We write further to previous consultations to comment on National Grid's proposed pylon route specifically proposed pylon locations RG34, RG35, RG36 and to put forward a proposed/suggested alternative new route as shown in yellow on the attached plan.

Yellow line =
suggested new route

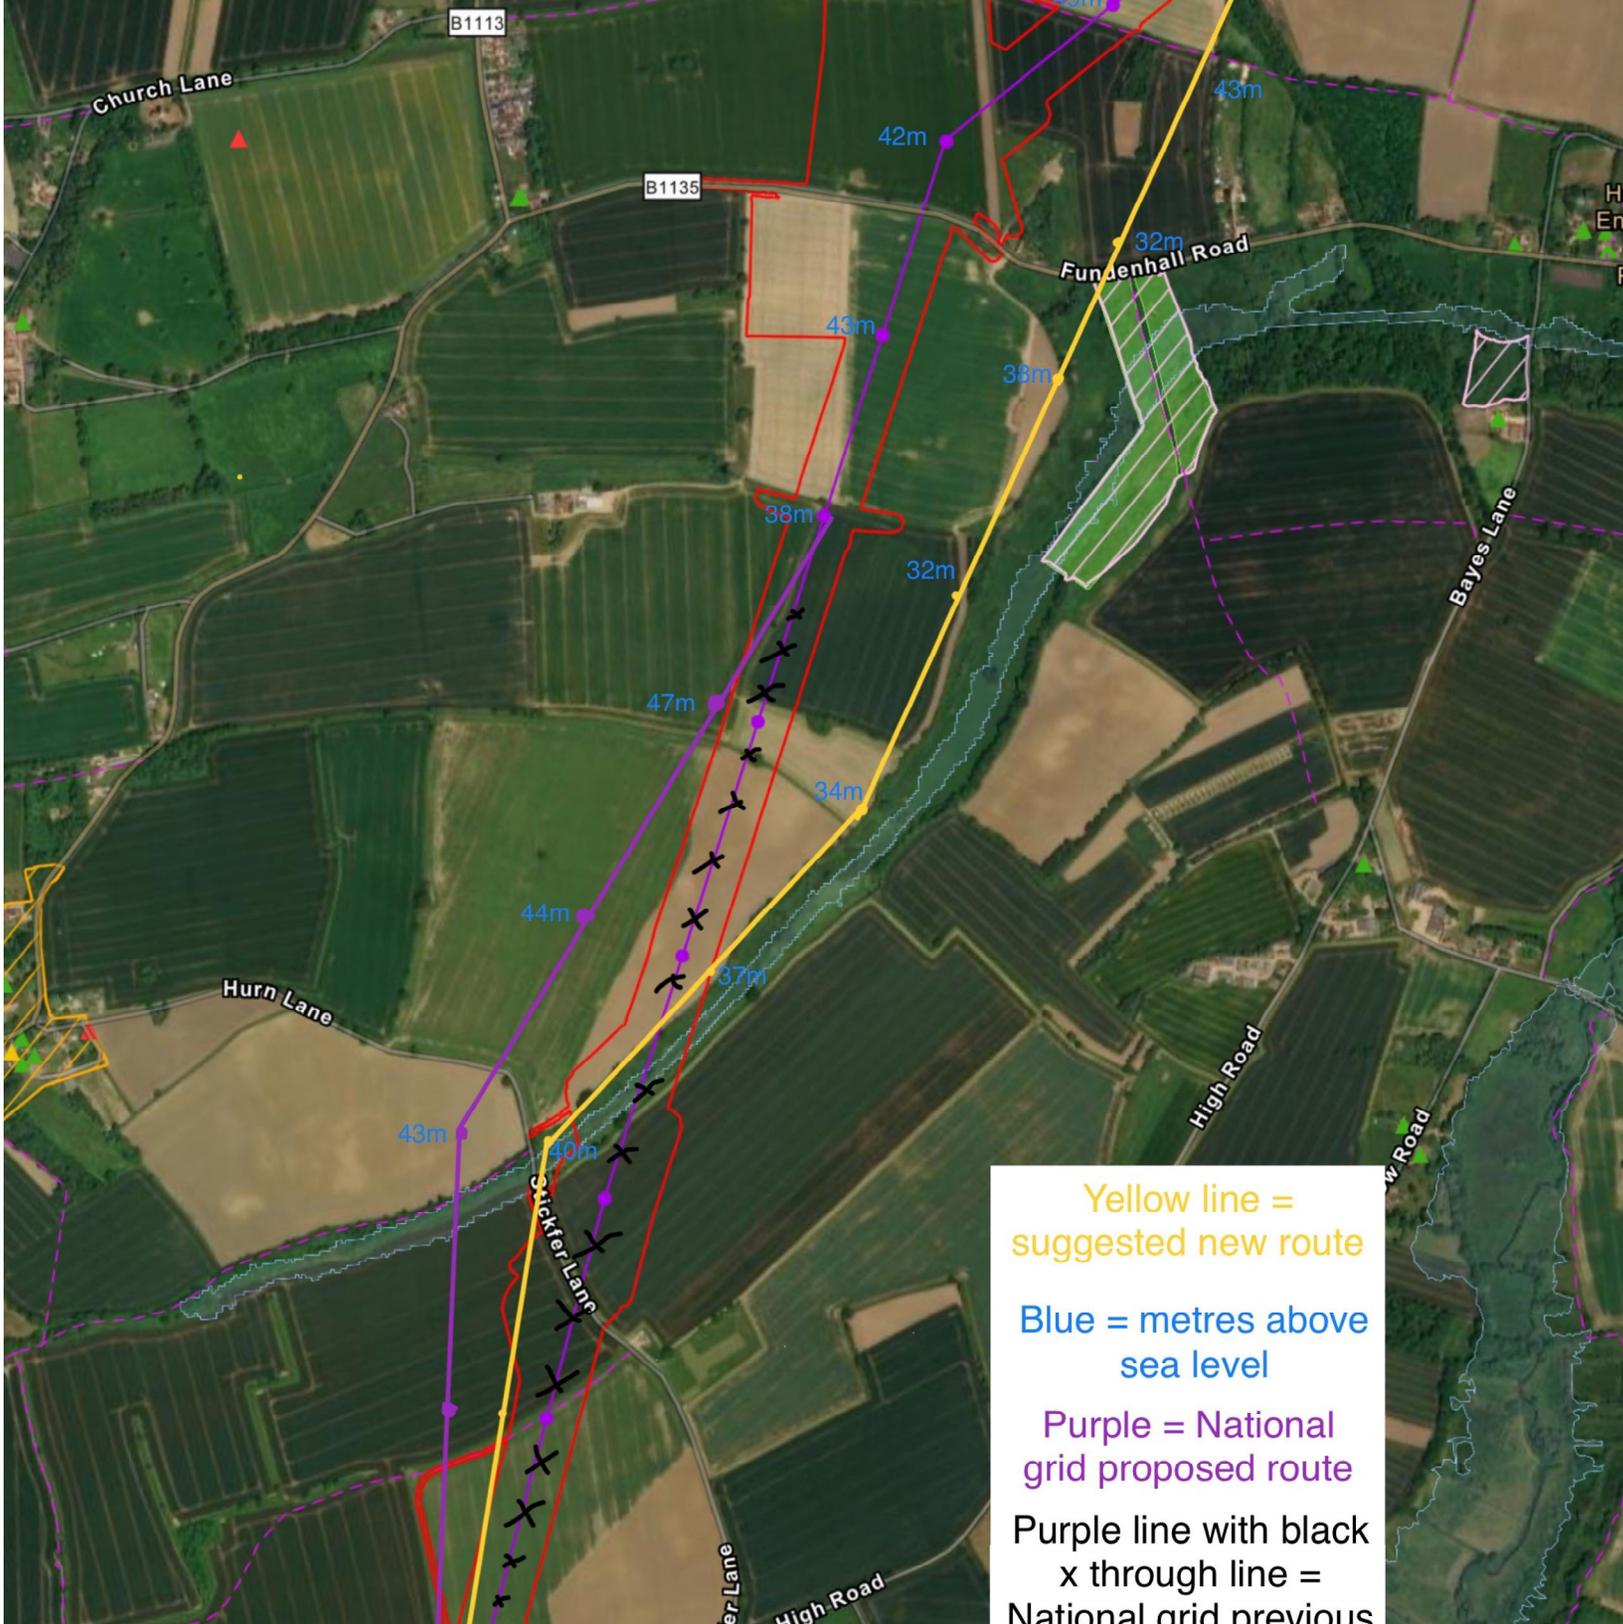
- Please see the attached plan with the suggested new route shown by a yellow line – this route runs along the bottom of the valley as opposed to National Grid's proposed route which runs on the higher ground to the west.

- The suggested new route is nearer the field boundaries with the pylons to be as close as possible to the field boundaries and, therefore, more compatible with modern farming methods as opposed to National Grid's proposed route.

- Specifically with reference to pylon RG36, this to be located as near as possible to the field edge to Cheney's Lane and the field corner with Cheney's Lane to the east.

- As shown on the attached plan in blue, the ground level for the suggested new route is considerably lower than the ground level on National Grid's proposed route and, therefore, the views of the pylons from surrounding land and properties will be considerably reduced.

- The provisions of the Holford Rules have been considered in the suggested route amendment and we believe that this route complies with the rules to a greater extent than the route proposed by National Grid.

- The suggested new route has the same number of angle towers as the National Grid proposed route but is a shorter route.
